**RE: DRB Approval of EPC approved
Site Plan for Building Permit 13EPC40097
Site Plan for Subdivision 13EPC40099
Project # 1009600**

Rio Grande Engineering requests approval of the enclosed site plans for subdivision and Building permit. The proposed development will be a two phased twenty four unit townhome apartment project located at the southwest corner of Alice and Cardenas NE. The following is a summary of the conditions of approval and a response as to how they were addressed:

Project# 1009600
13EPC-40097 Site Development Plan for Building
Permit
13EPC-40098 Zone Map Amendment (Zone
Change)
13EPC-40099 Site Development Plan for
Subdivision

SITE DEVELOPMENT PLAN FOR SUBDIVISION 5600 ALICE AVENUE NORTHEAST

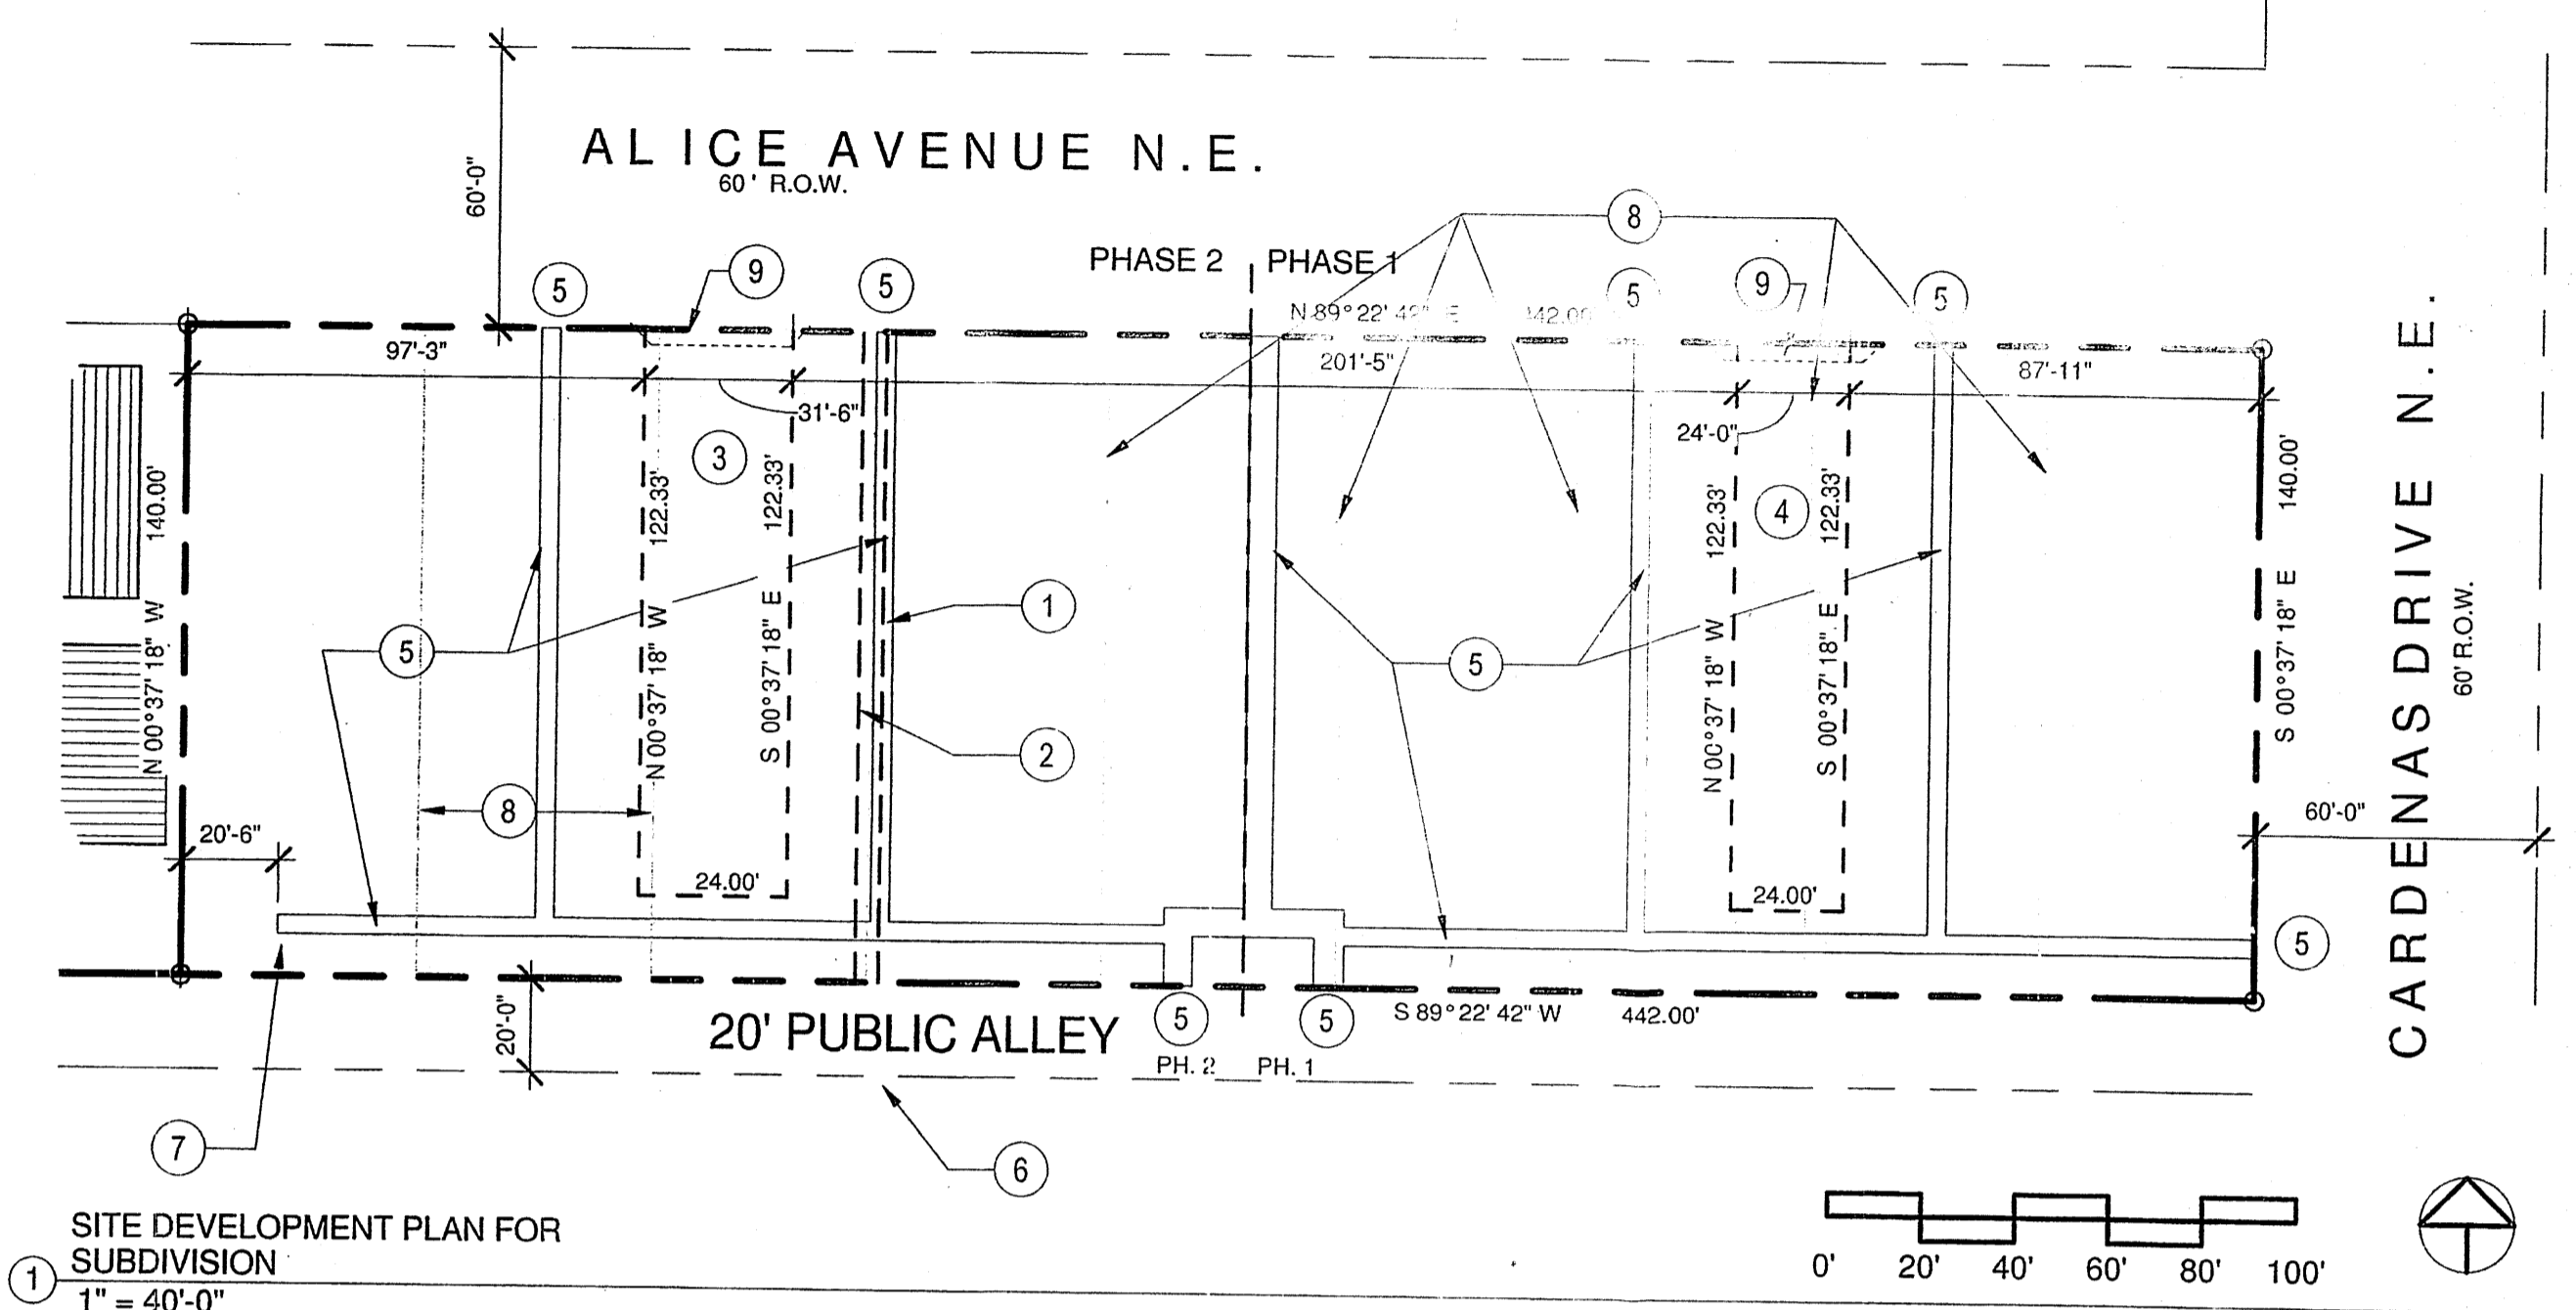
- c. All easement shall be shown and labeled

We have shown all existing easements, the site plan for subdivision was most appropriate place for many of the proposed easements for clarity

DRAWING TITLE: SITE DEVELOPMENT PLAN FOR BUILDING PERMIT

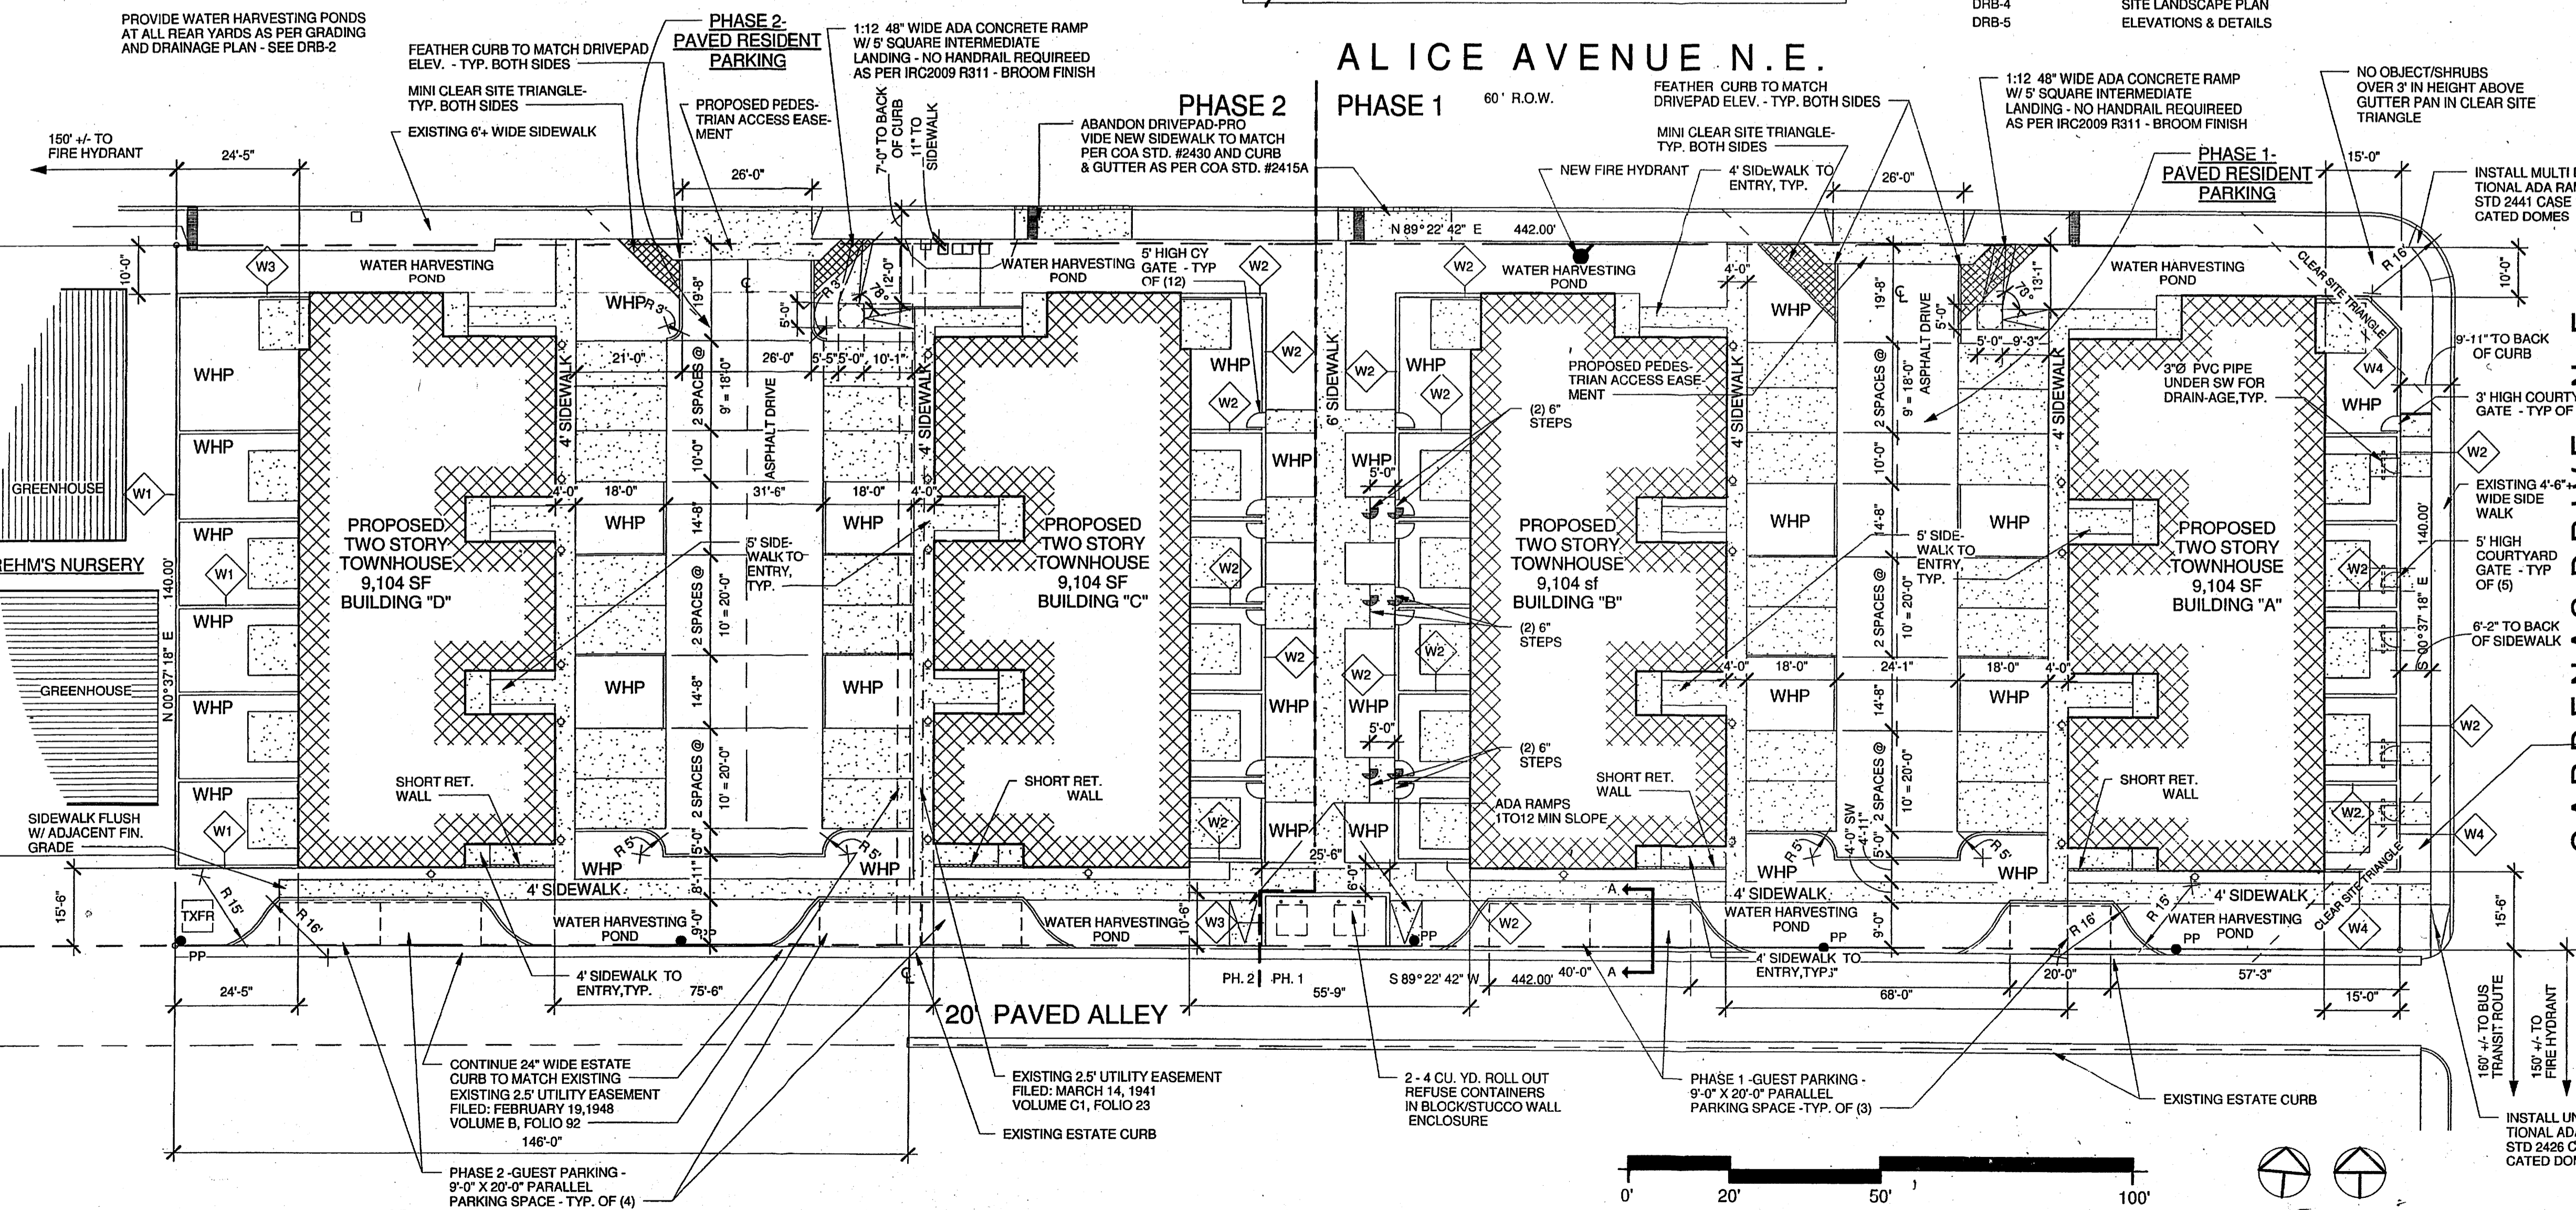
- a. Provide and label and detail all infrastructure and easements on site plan

- b. Site plan shall comply with DPM and ADA

- e. Revise courtyard walls to comply with DPM

We have labeled all relevant on site plan

We feel the site plan meets DPM and ADA standards

We have revised the walls and labeled the clear site areas

DRAWN BY: WCWJ	DATE: 5-20-13	PROJECT NO.: TRY24
21302-LAYOUT-1-09-13	SHEET #	DRAWING NO.
JOB # 21302	DRB-2

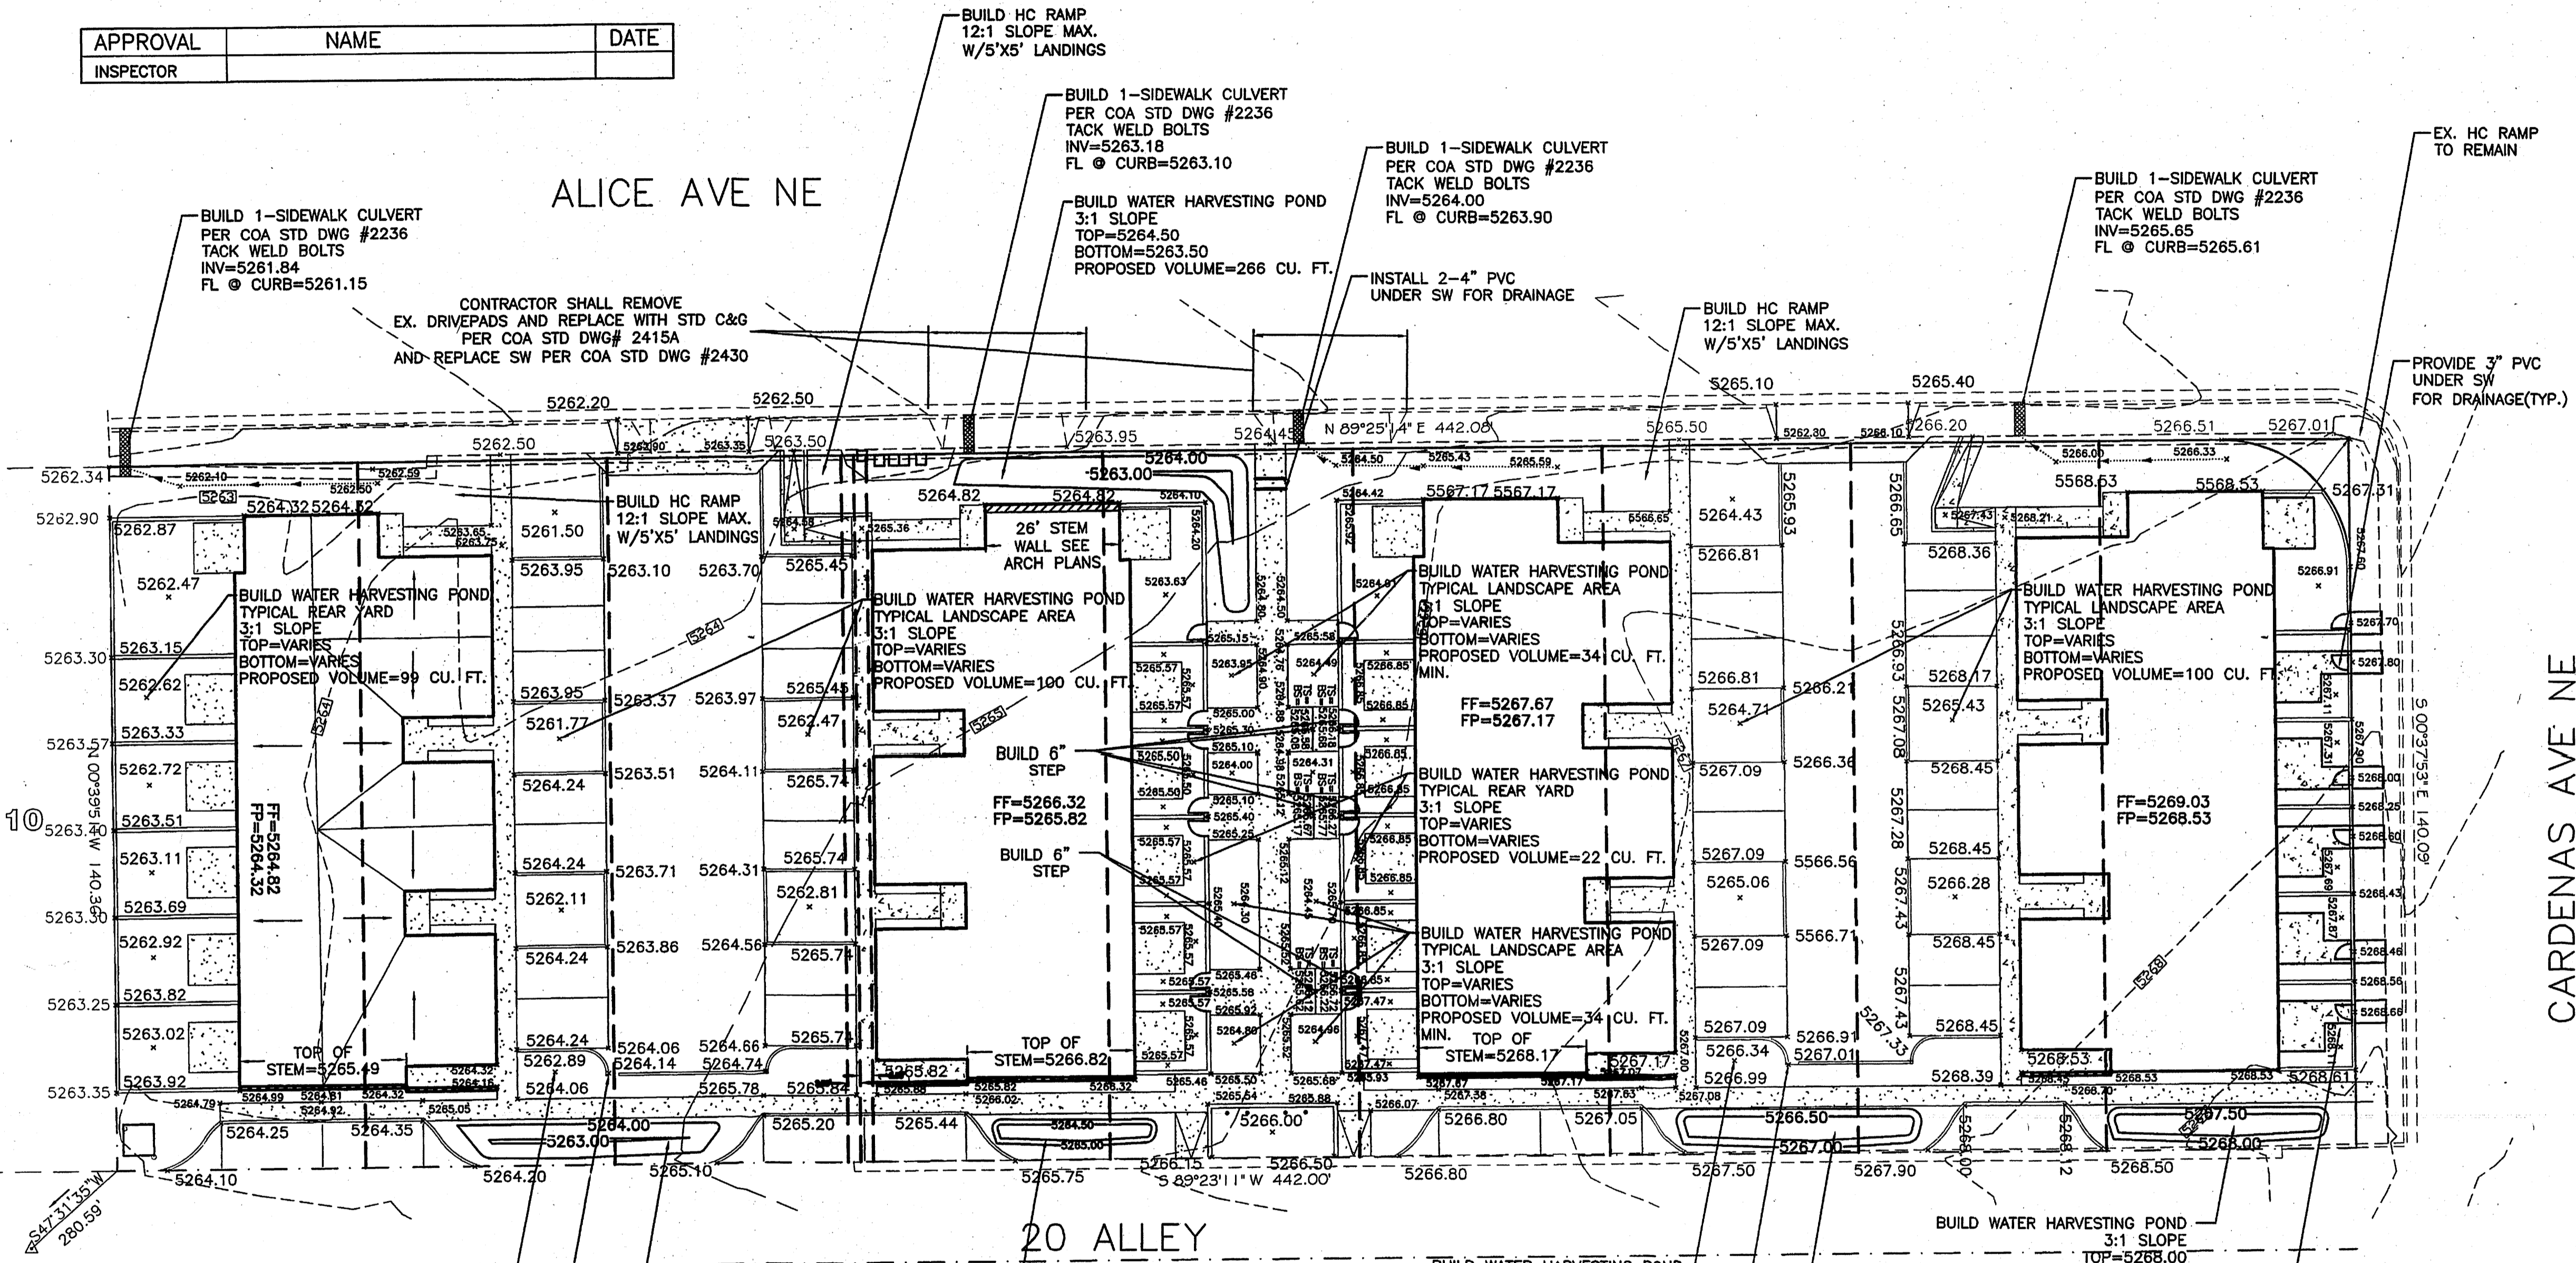
- f. Roof flows from building D shall drain to Alice, courtyards shall pond what falls on them

- g. Submit grading plan to Hydrology

The grading plan conforms

A grading and drainage plan has been submitted and should be approved prior to hearing.
